**Transport
for NSW**

DUBBO ZIRCONIA PROJECT

Annexure to TfNSW submission to Dubbo Zirconia Project

Figure 4: Indicative Gas Pipeline Corridor.

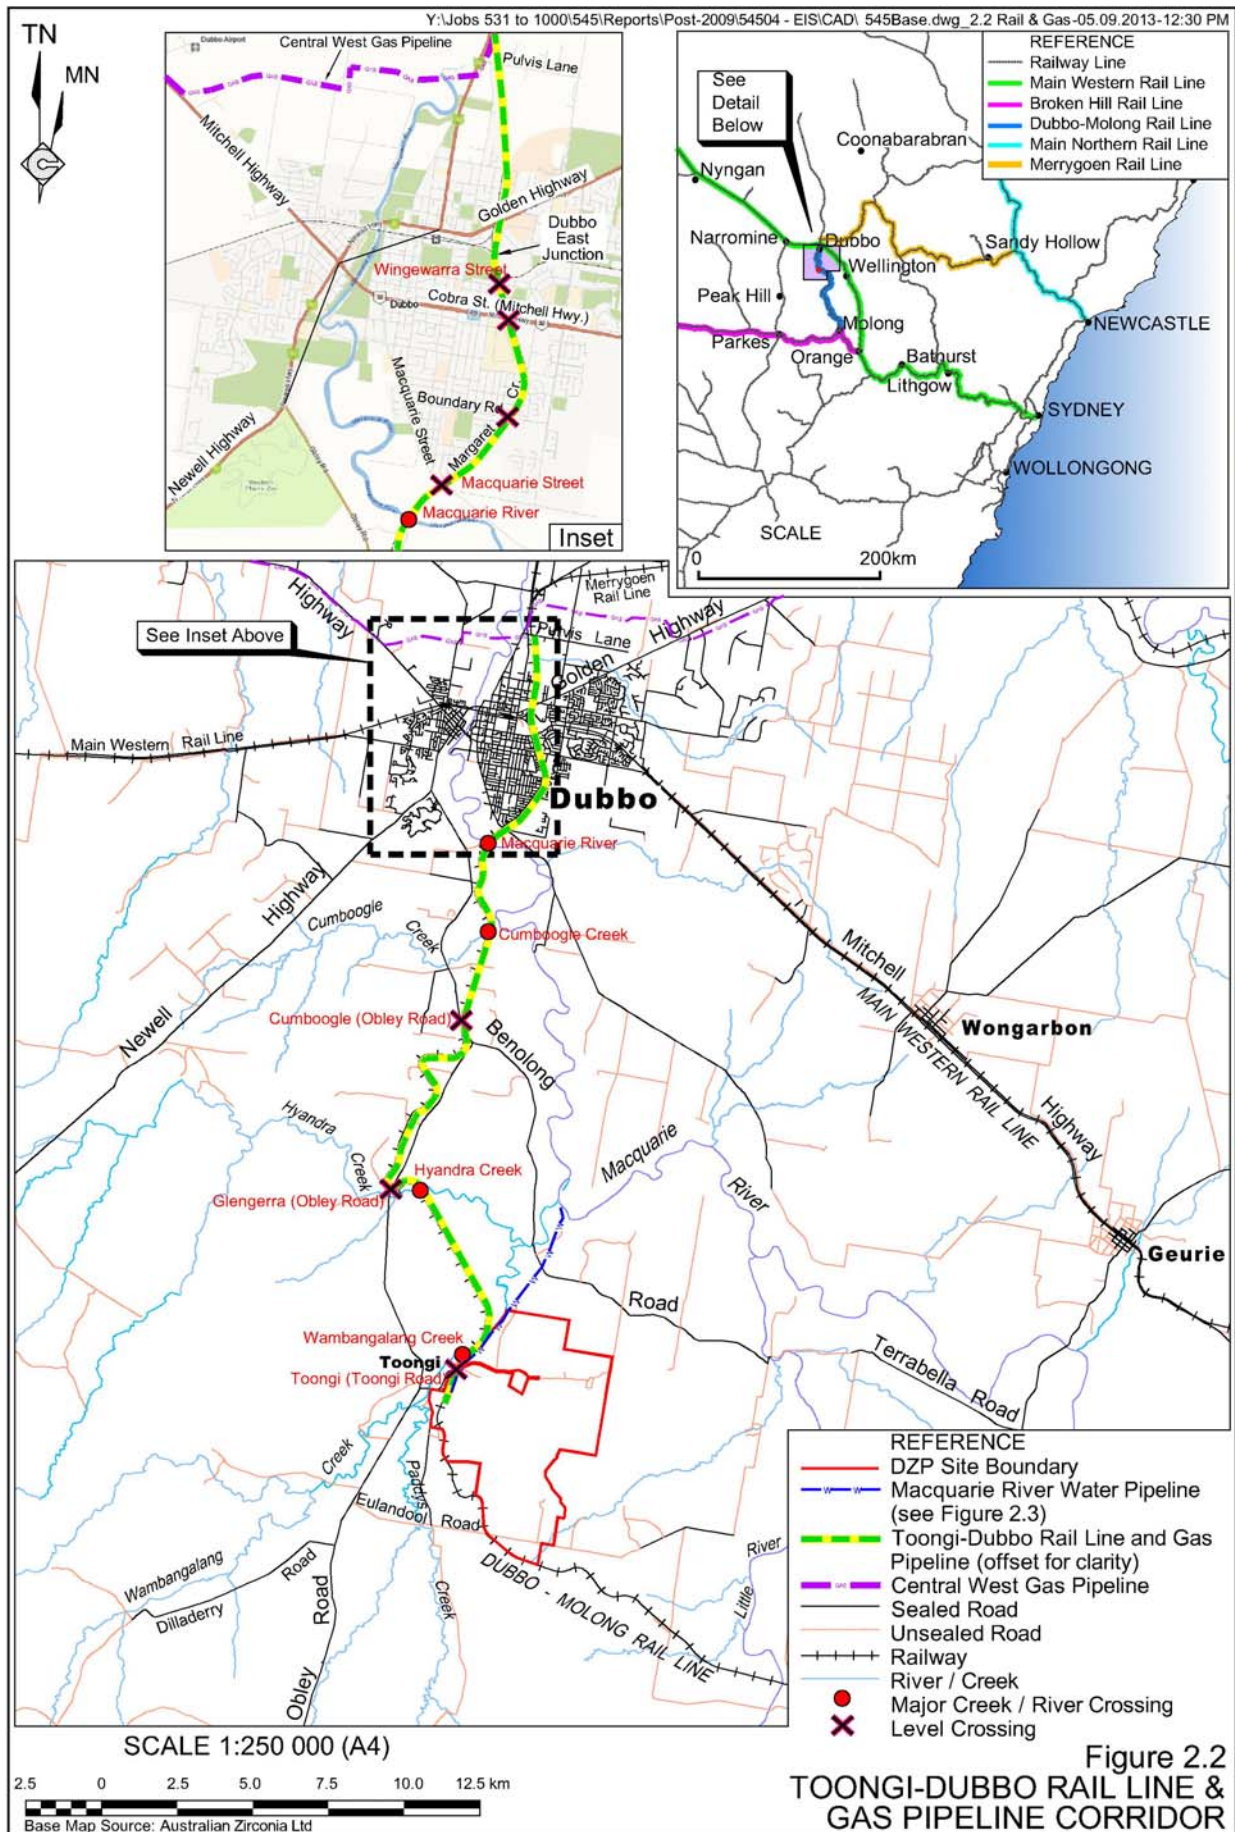
9. Further detail on the proposed gas pipeline to be contained within the rail corridor, regarding the design (including its proposed location in relation to the rail track and any proposed structures), construction and operation of the pipeline. The design must comply with all other aspects of CRN CS 540 Service Installations in the Rail Corridor. However, Transport for NSW would prefer that the pipeline is constructed

outside the rail corridor. Further comments surrounding the gas pipeline are included in **Tab B**.

1. The applicable codes and standards regarding the pipeline include CRN CS 540: Service Installations in the Rail Corridor, (CRN CM 541 Service Crossing – for guidance on process) and Australian Standard AS 1799-2000: Installation of underground utility services and pipelines within railway boundaries. Compliance with these standards is required for safety accredited rail operations on the corridor.

2. Transport for NSW notes that trenching was specified as the main installation method and that the EIS specified minimum trenching to 750mm. The provisions mentioned above include a minimum depth of 1200mm in accordance with AS4799 Fig. 5.2. Any trenching works must also ensure that stability of all embankments and cuttings during construction and/or restoration is maintained. This must be certified by a qualified Geotechnical Engineer.

3. The pipeline must be designed to withstand R20 vehicle loading, and where it crosses under the rail track, it must be designed to the requirements of CRN CS 540 – 6.3.4.

4. Transport for NSW also notes that encasing pipes is required for any track crossing.
5. It should be noted that attaching pipelines to any rail under bridges or structures is not permitted. Transport for NSW requires that the proposed alignment of the pipeline provides sufficient clearance to enable renewal of existing infrastructure without any impacts to the pipeline or the requirement of any special procedures.

6. Transport for NSW notes that by upgrading the pipeline prior to the rail line, protection requirements for the operational pipeline during track upgrade works is likely to significantly increase costs. It is recommended that the detailed design of the pipeline and the track alignment is coordinated.
